Job ID: 2011-10-2383-FAFS
Installation of master box fire alarm system

For installation at:
1372 CONGRESS ST
Westgate Shopping Plaza

Benjamin Wallace - Re: Anytime Fitness Fire Alarm Permit

Drawing file: Fire Prevention / CD195627 Model (1).pdf

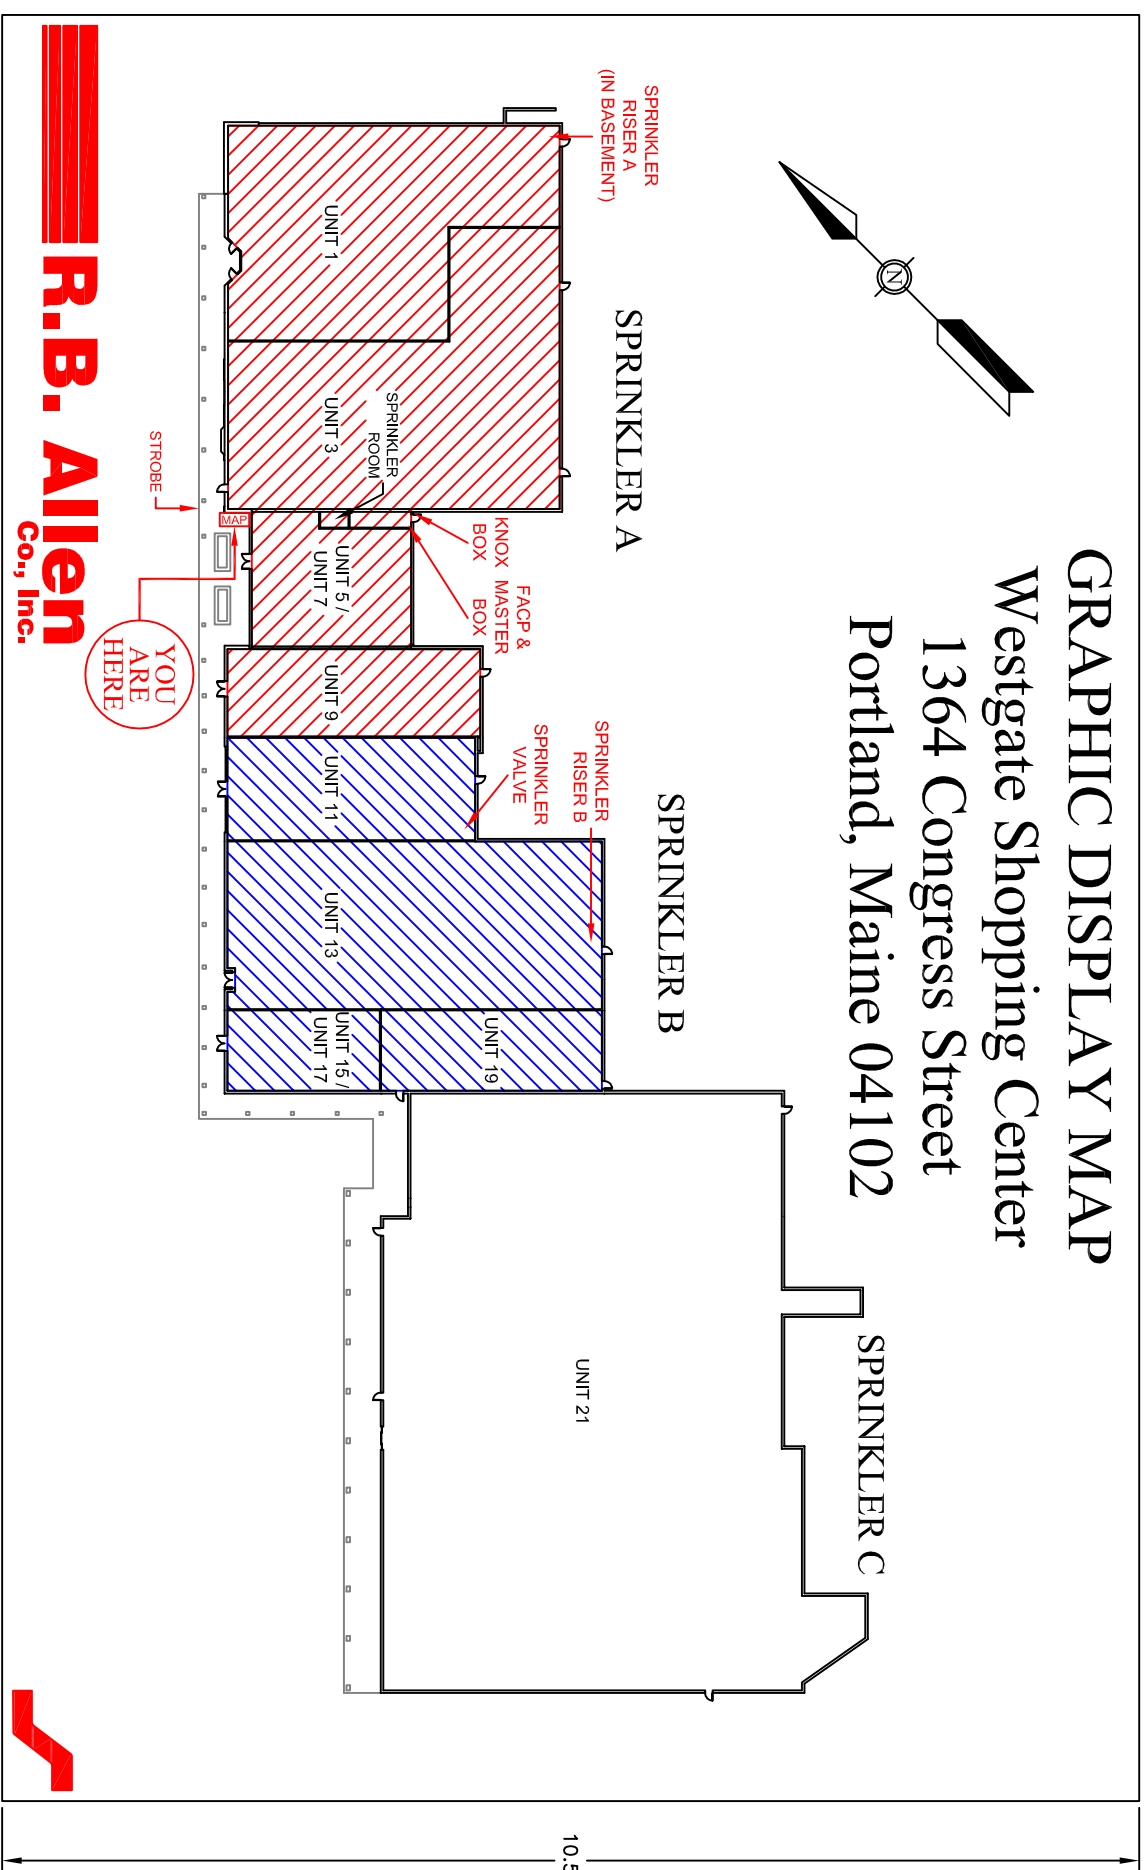
The annunciator appears to be a "conventional annunciator" with 16 zones. Going by memory I think there's 10 tenant spaces and two sprinkler systems to be monitored eventually. Is this the case and is the annunciator "full function" so we can silence and reset it without going to the FACP out back? At the minimum each tenant space and each sprinkler system must be annunciated separately (not separate annunciators) and you need a graphic annunciator above the annunciator panel out front depicting the plaza, each tenant space and alarm device, the location and identification of each sprinkler riser, and the location of the FACP and master box. I need voltage drop and battery calcs. All alarm controls should be operated from the central FACP and annunciator. We're not going to silence or reset systems from two different locations. The Knox Box out back needs to be a 3200 series or larger hinged model. The Knox Box out front at the annunciator location will require a either a 4100 or 4400 series Knox Box for plaza keys.

The Space Age Electronics M16 annunciator without full function capabilities is approved with the following provided:

A red revolving light shall be provided in the overhead directly in front of the annunciator and the fire alarm room;

A sign shall be installed over the annunciator that states:

A graphic map shall be provided over the annunciator depicting suite letters, location of the FACP, and the sprinkler risers. These suite letters shall be used to annunciate non water flow alarms.

Each annunciator zone shall indicate only one tenant alarm and each sprinkler water flow shall be separately annunciated.

Knox Boxes shall be installed as follows: one model 4100 or 4400 at the annunciator; One hinged model 3200 or larger at the fire alarm room.
